## Planning Consultation Memo

<b>Date: 12 October 2022</b>	<b>Planning Officer: Elizabeth Mugova</b>	<b>Landscape/Tree Officer: Oliver Waring</b>
<b>Planning Application Number</b>	<b><u>6/2022/1943/FULL</u></b>	Erection or a new dwelling with associated landscaping works

<b>Context</b>	
<b>Site Address</b>	Land between 48 and 50 The Ridgeway, Cuffley EN6 4BA
<b>Relevant Constraints/Policies</b>	<p><b>WHDP 2005</b></p> <p><b>R11 – Biodiversity and Development</b> – all new development will be required to demonstrate how it would contribute positively to biodiversity of the site by retention and enhancement of the natural features on site.</p> <p><b>R17 – Trees, woodland and hedgerows</b> – the council will seek the protection and retention of these features and require when appropriate new, native planting.</p> <p><b>D8 – Landscaping</b> – the council will require the retention and enhancement of existing key landscape features (requiring detailed surveys)</p> <p><b>Policies from the Draft local plan -</b></p> <p><b>SP11 – Protection and enhancement of critical environmental assets</b> – protection, enhancement and management of the environmental, ecological and historical assets

South West Elevation A (as seen from the main road - with trees)

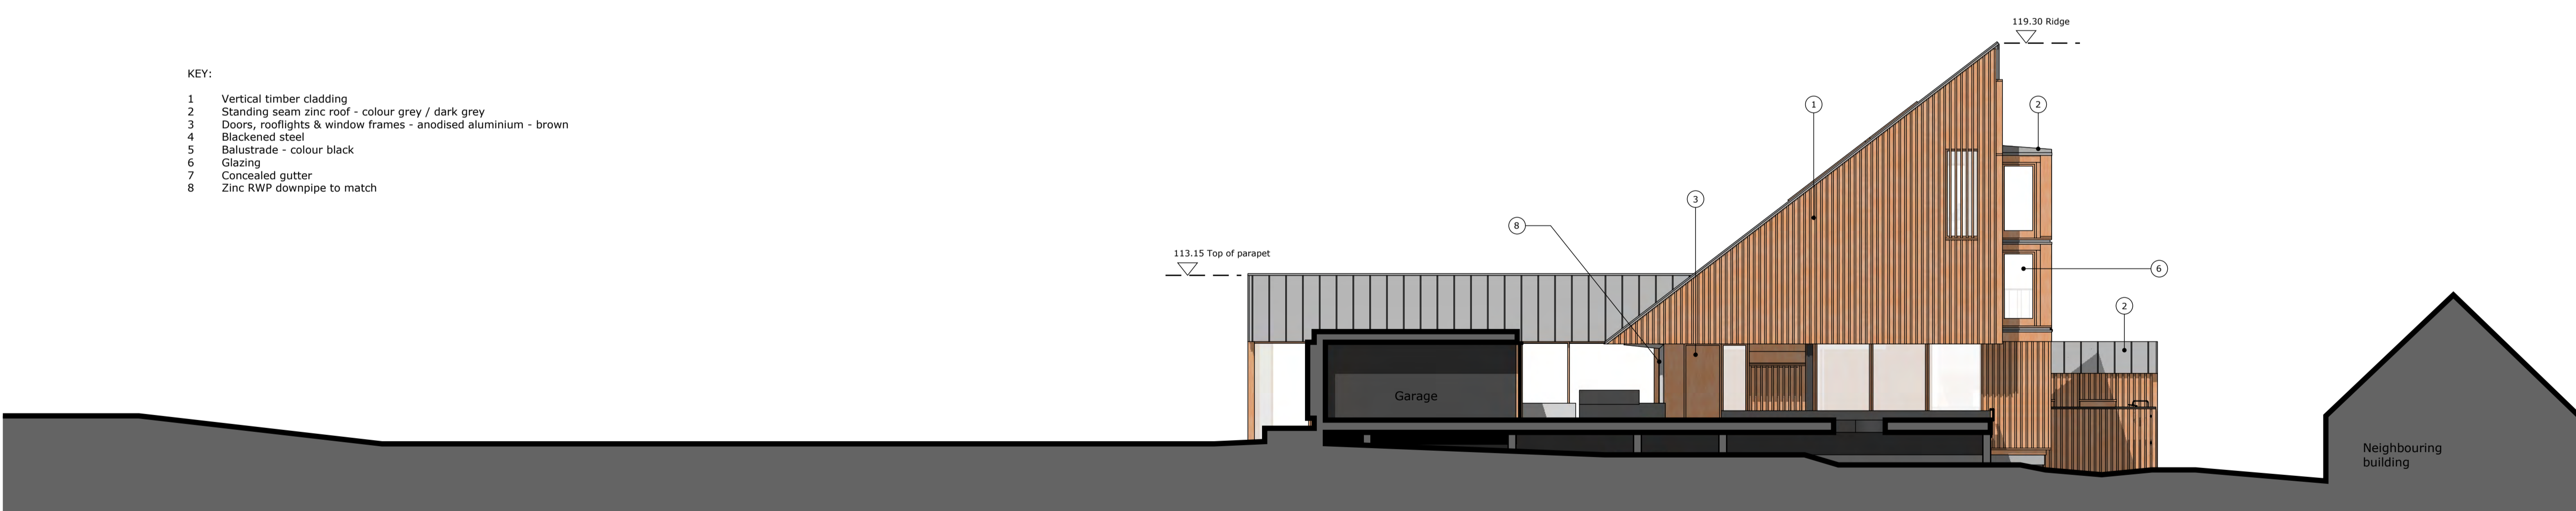
There is no information regarding the impact of shade on the dwelling. Many of the computer-generated images show the trees with minimal or no leaves. When the trees are in full leaf the proposed house would be in significant shade. Experience would indicate there would be an increased pressure to prune the trees or requests to prune for light via a TPO application.

Title Root Protection Areas - Sheet 2

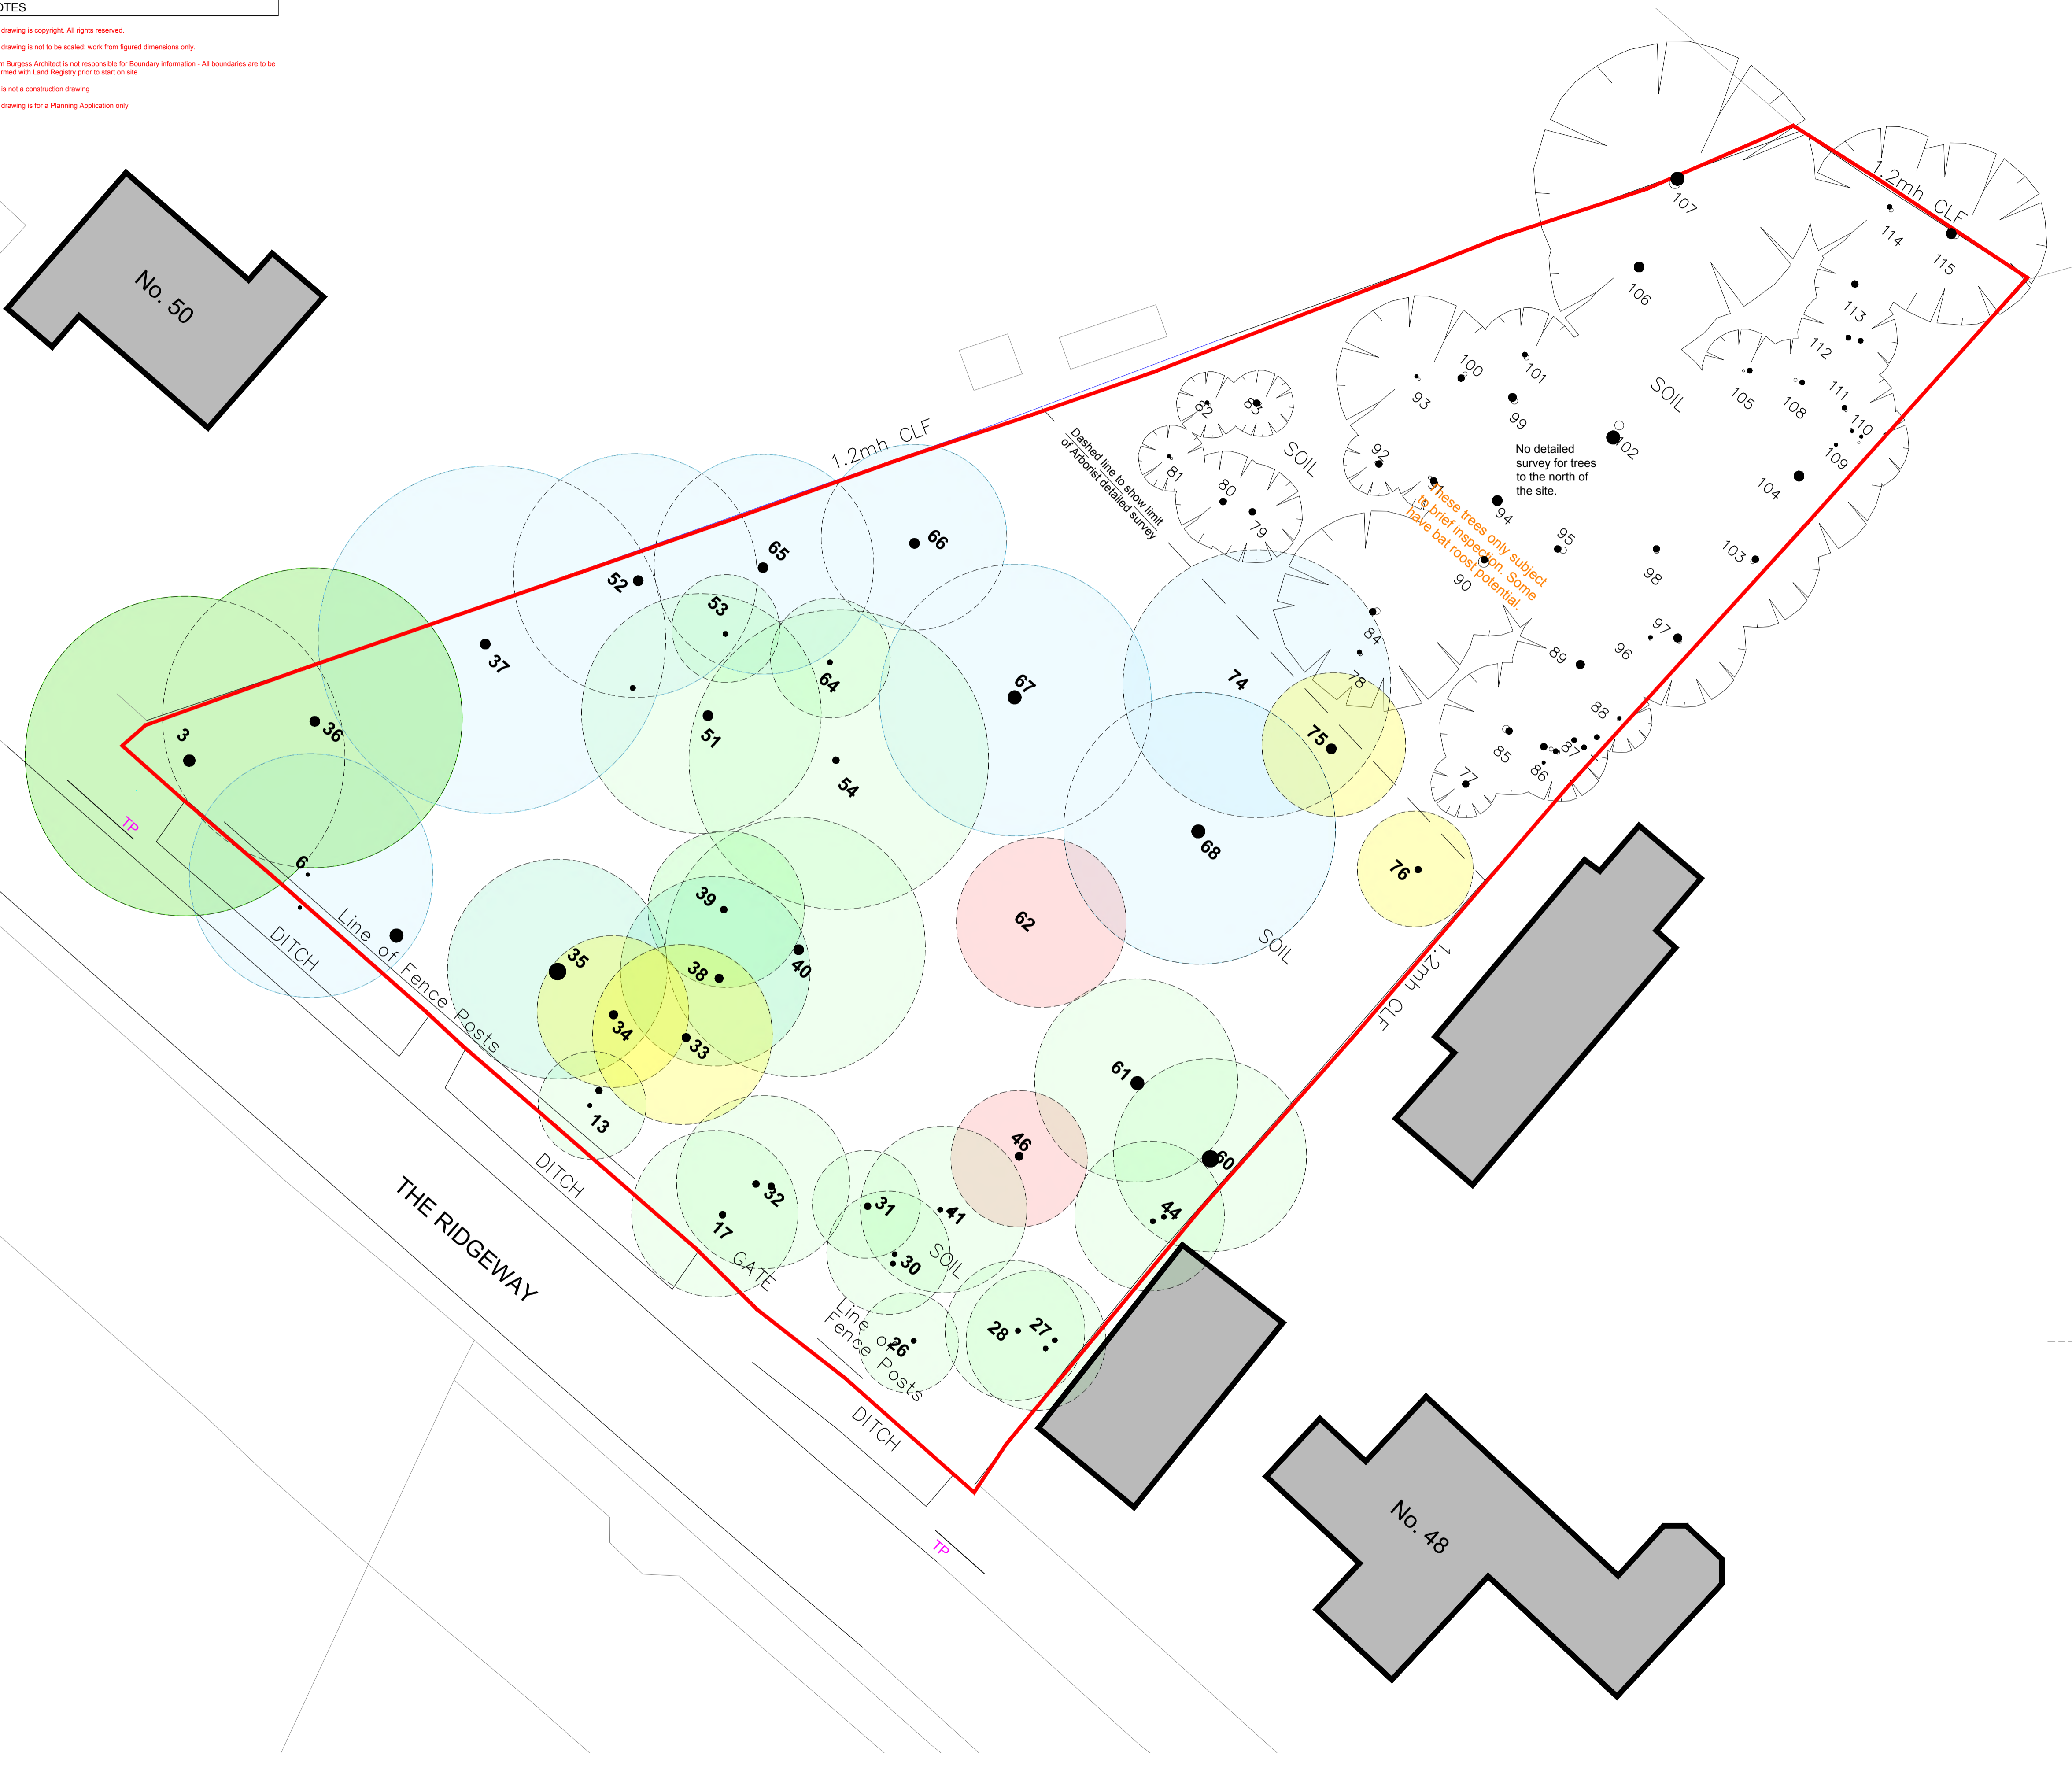
**Comment:** It is not clear from the information submitted how many trees are to be removed but the Planning statement submitted states:

*A desire not to remove trees of worth and to minimise disruption to the site pointed to the most appropriate location being where trees T46, T62 and T63 are located; all are classified C with limited lifespan, T46, a Hornbeam is dead in its larger stem and both T47 and T63 are Ash trees which are*

*almost dead, both visibly suffering Ash dieback. To utilise this space would also require removal of T62 a small Hornbeam classified C. In addition to these, tree T70, a class C Ash tree is also required to be removed as it too is nearly dead.*

It also not clear if the applicant has considered the construction of the building and its impact on the trees. For example, the use of pile foundation is mentioned which requires specialist equipment with the need for height clearance and manoeuvrability around the site. Site storage and site compounds are also consideration that will affect the trees on site.

Title Root Protection Areas with Proposed

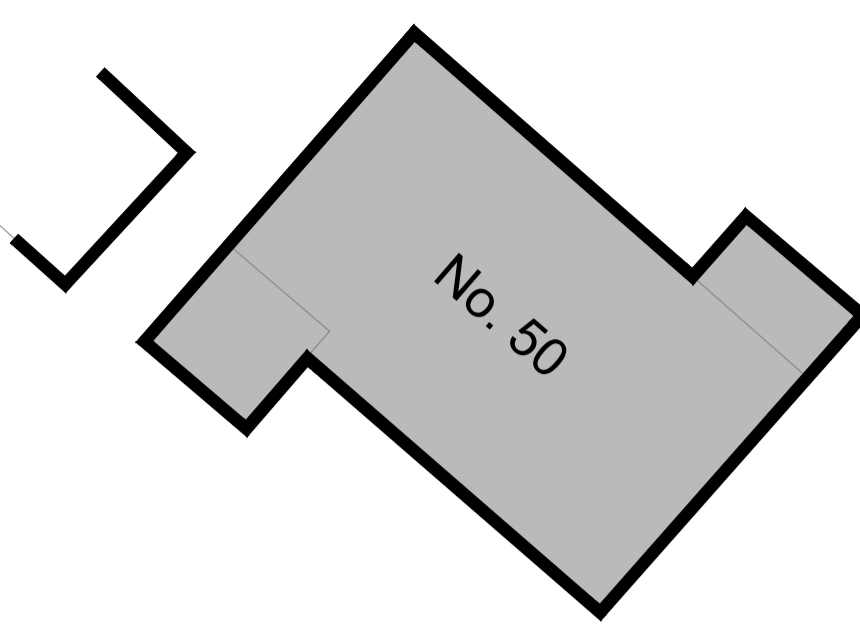
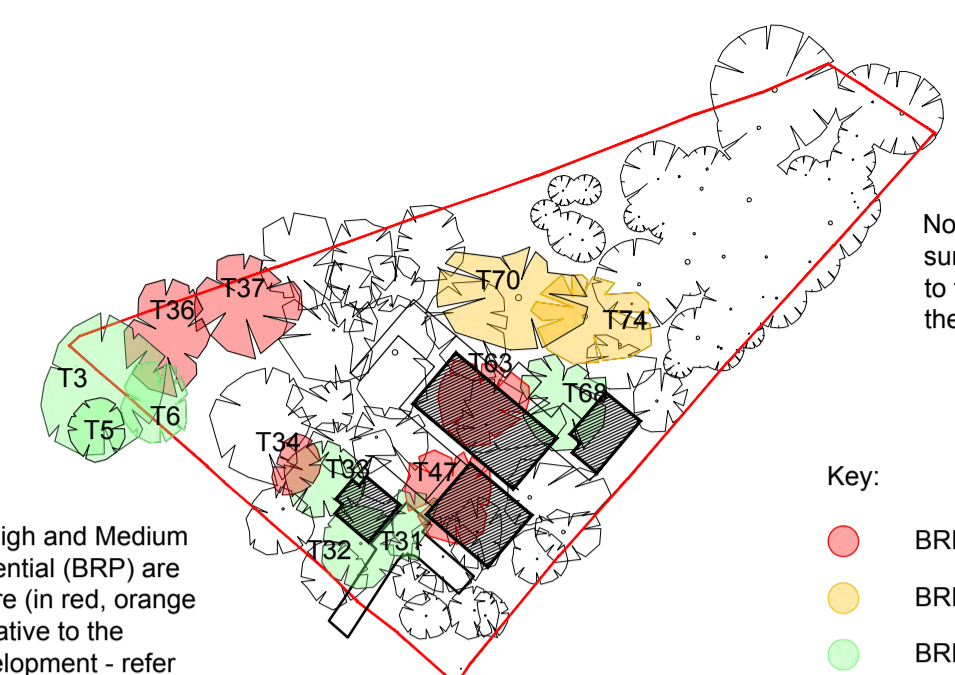
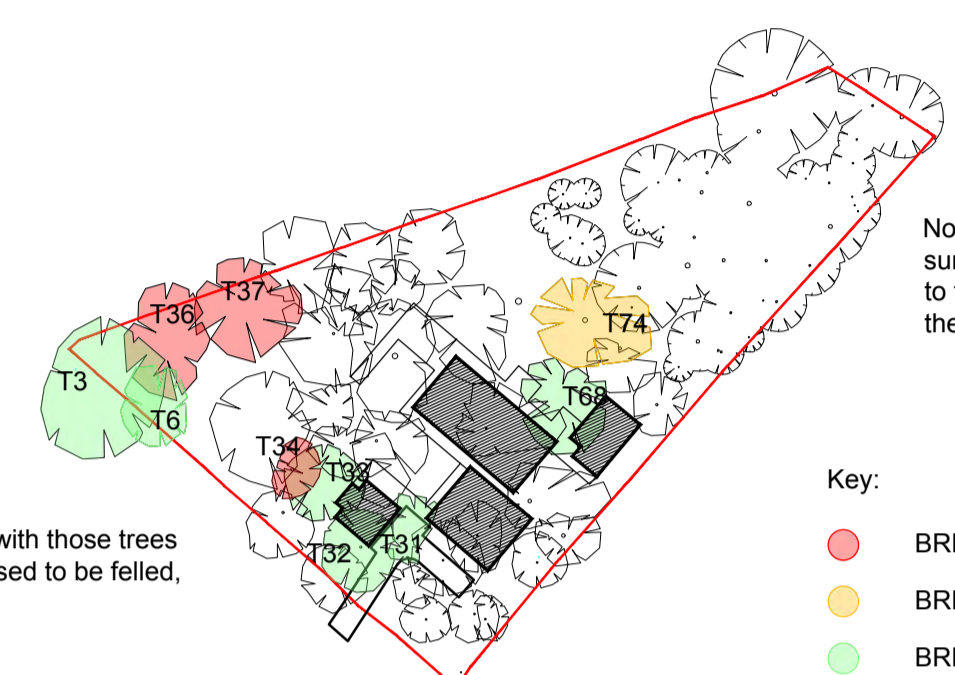
There are concerns about the impact of the construction process on the trees in particular the requirement for specialist equipment for pile foundations.
